National Infrastructure Planning  
Temple Quay House  
2 The Square  
Bristol, BS1 6PN

Our Ref: TR020002

### **Application by RiverOak Strategic Partners for an Order Granting Development Consent for the upgrade and reopening of Manston Airport**

#### **Advice following issue of decision to accept the application for examination**

Figure 3.1
Masterplan - site layout

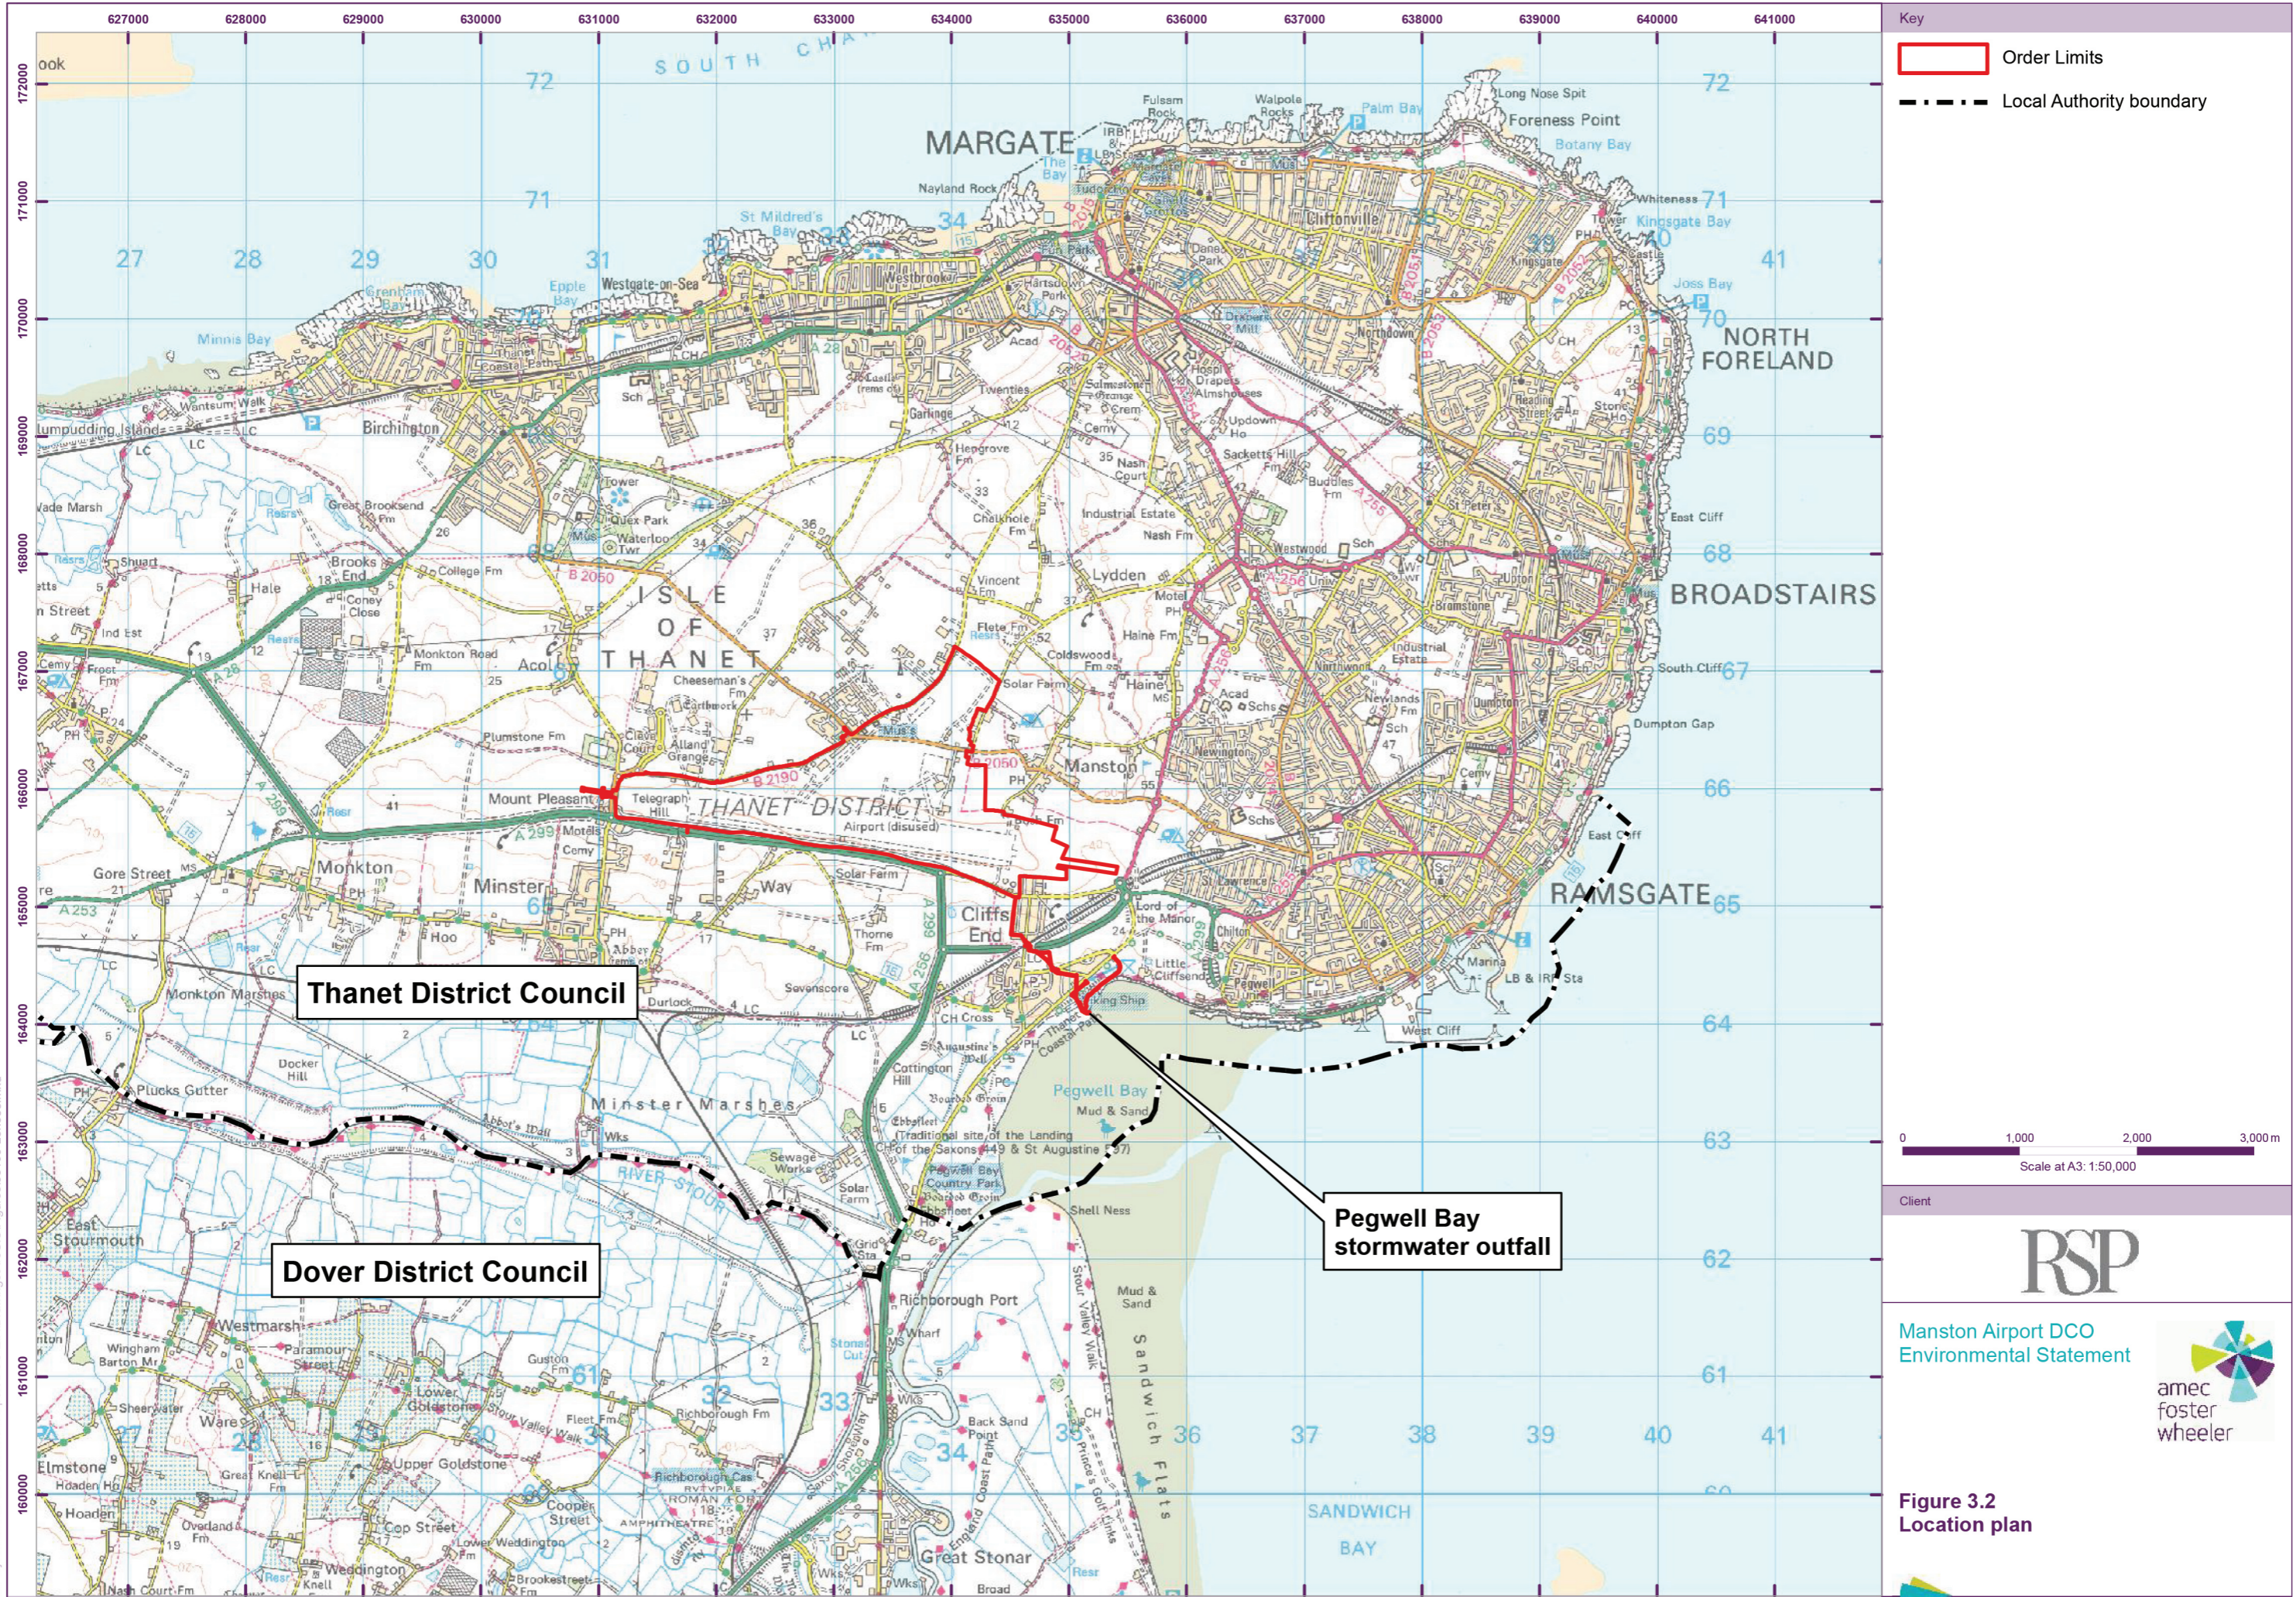
The appointed ExA is also likely to request details regarding the proposed dimensions of the "site gatehouse" shown in ES Figure 3.1 and mentioned in Table 11.68 of the ES.

Figure 3.1 of the ES (Doc 5.2-4) refers to the relocation of the existing Ministry of Defence (MoD) aerial, however this is not mentioned in the ES or the draft DCO. The appointed ExA is likely to seek for the Applicant to confirm its intentions for the MoD aerial.
